RE: SUBMISSION ON THE METROLINK ON BEHALF OF JERDIP PROPERTIES UNLIMITED COMPANY IN
RELATION TO PROPERTY AT THE ARTHUR COX BUILDING, 10 EARLSFORT TERRACE, DUBLIN 2,
D02T380

ABP Ref. NA29N.314724

Project Title	Project Metrolink – The Arthur Cox Building	From	Robert Coughlan, PUNCH Consulting Engineers
Project No	222273	To	An Bord Pleanála
Subject	Technical Submission to Railway (Metrolink–Estuary to Charlemont via Dublin Airport) Order 2022 at The Arthur Cox Building, 10 Earlsfort Terrace Dublin 02 T380	Cc	
Date	12-01-2023

2.0 Technical Observations

Figure 20.16 Settlement Contours
Sheet 26 of 28

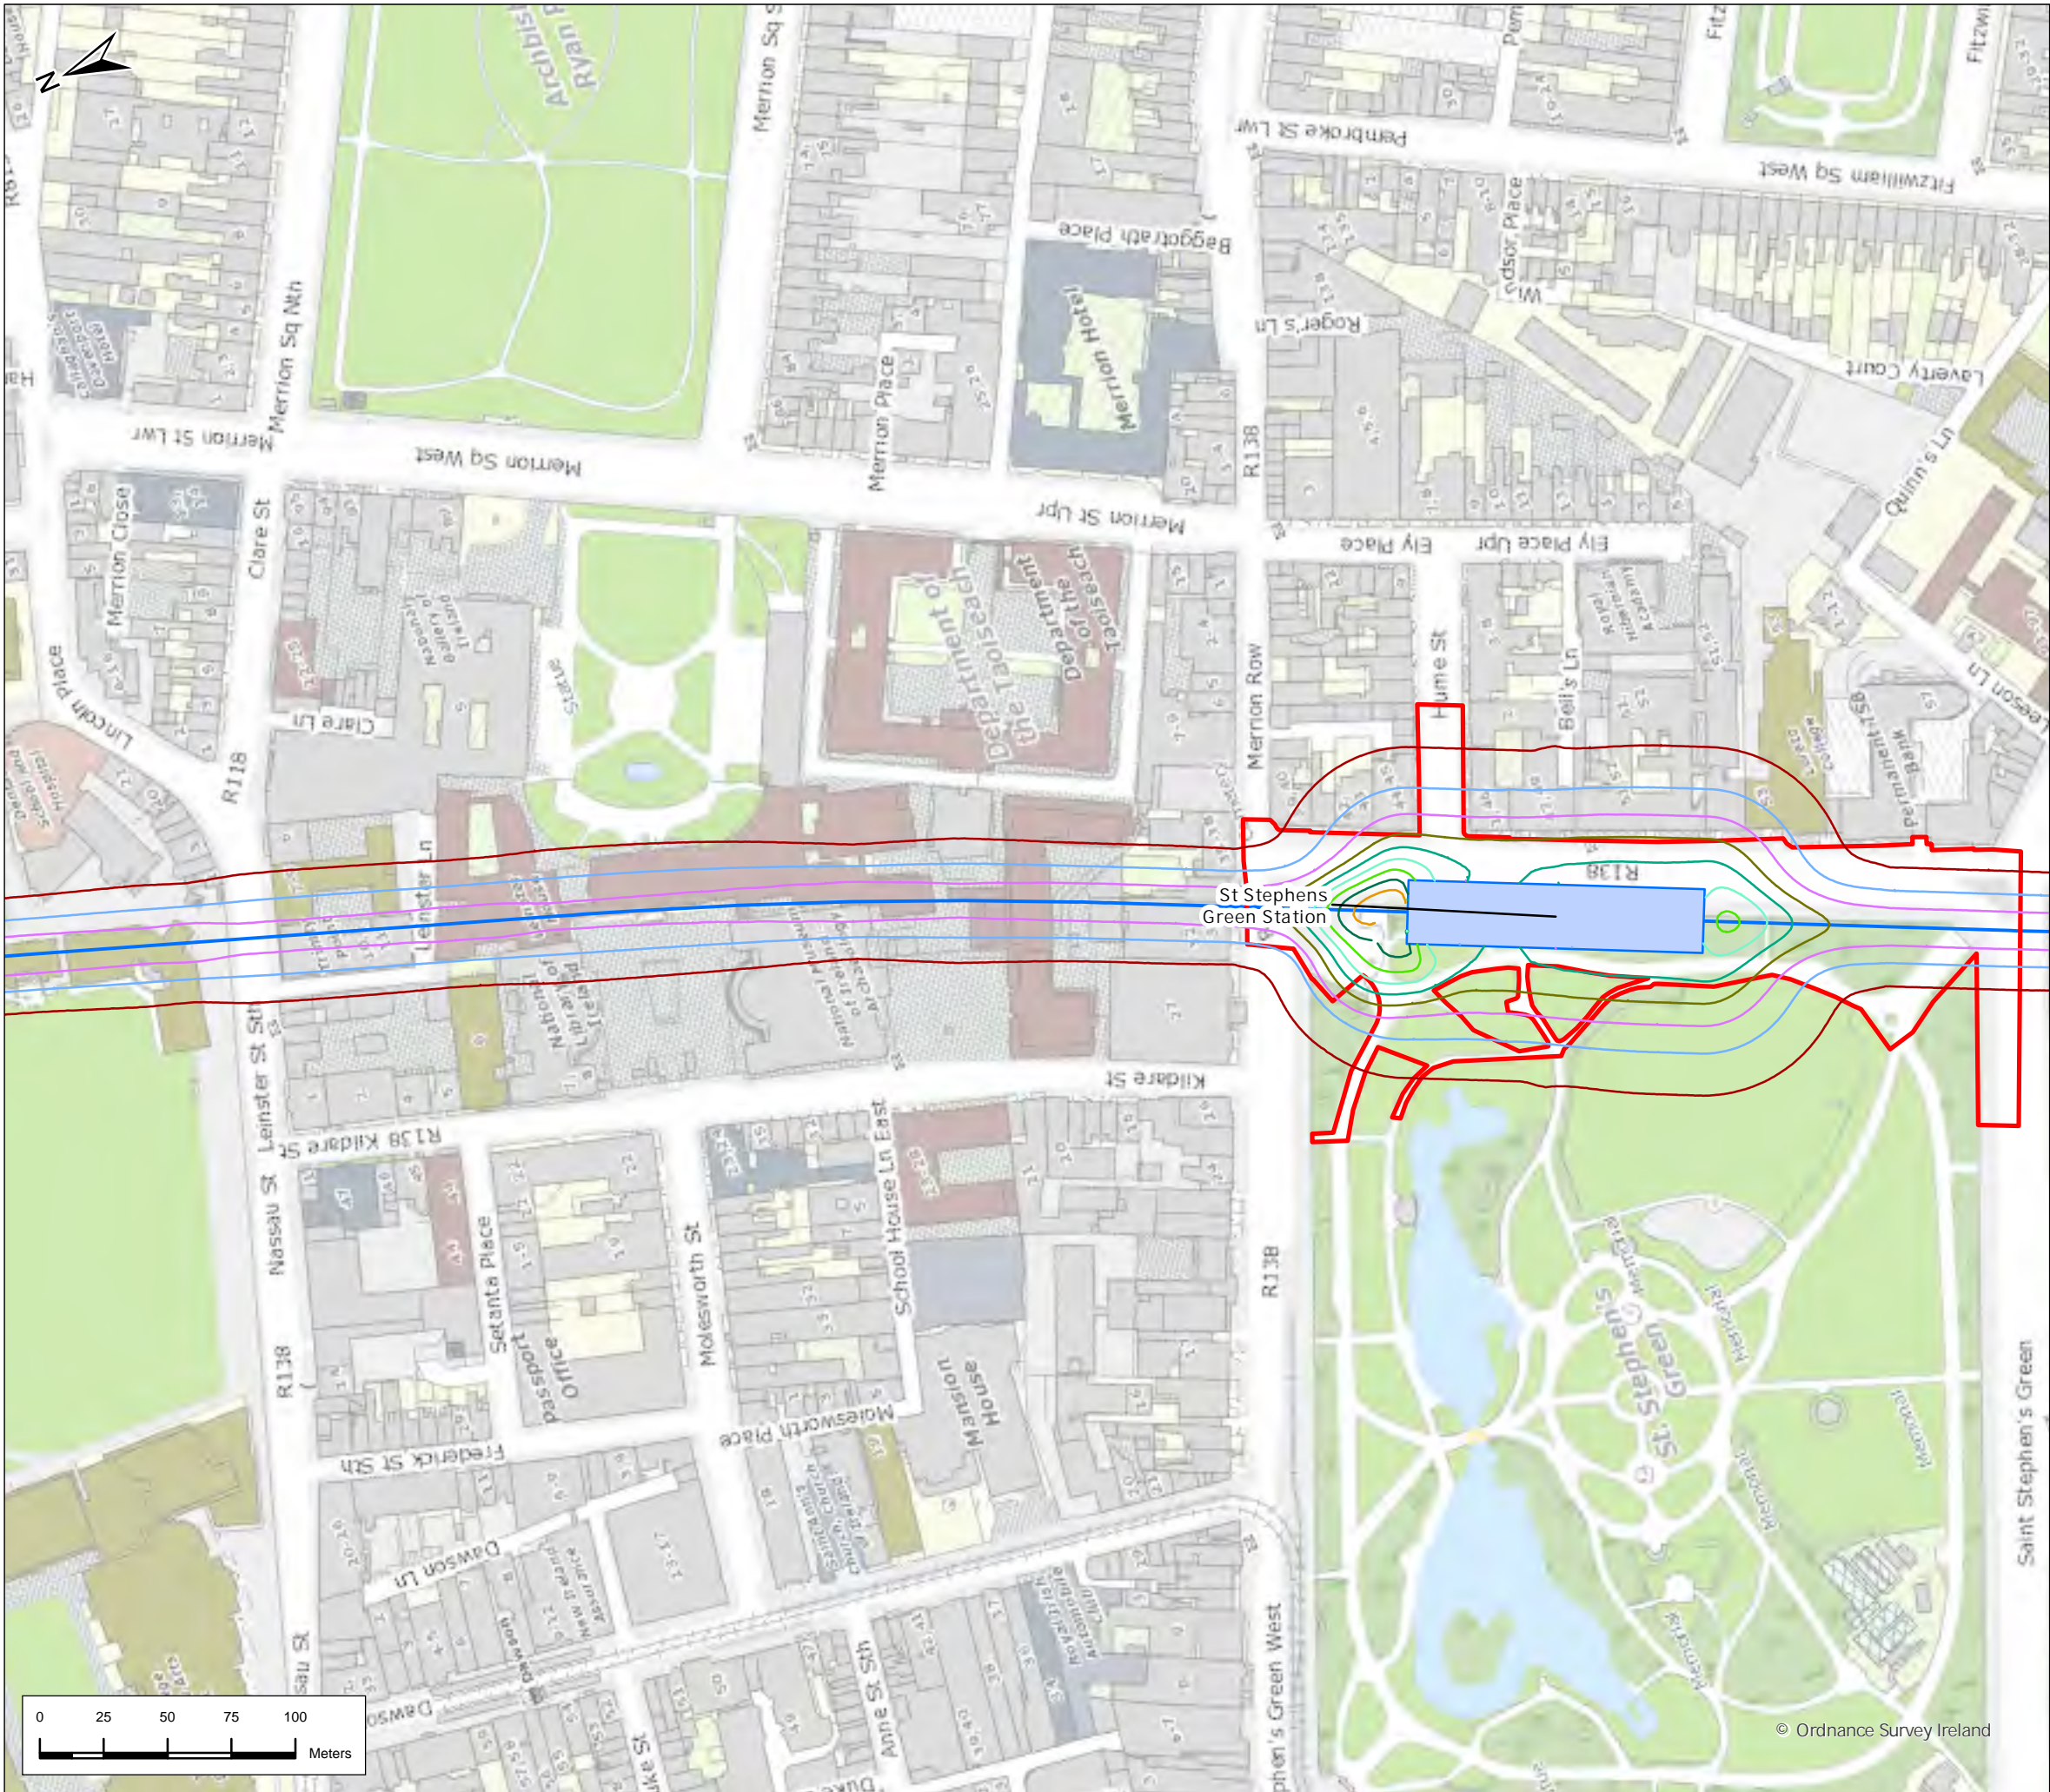
- i) The predicted settlement is a concern from available information on <https://www.metrolinkro.ie/>. The settlement contours on Volume 4, Chapter 20- Fig 20.16, sheet 29 of 30 (Refer to Appendix B), suggest settlement of 40-45mm in the calculated settlement trough. We request details from TII on how they established this deflection data.
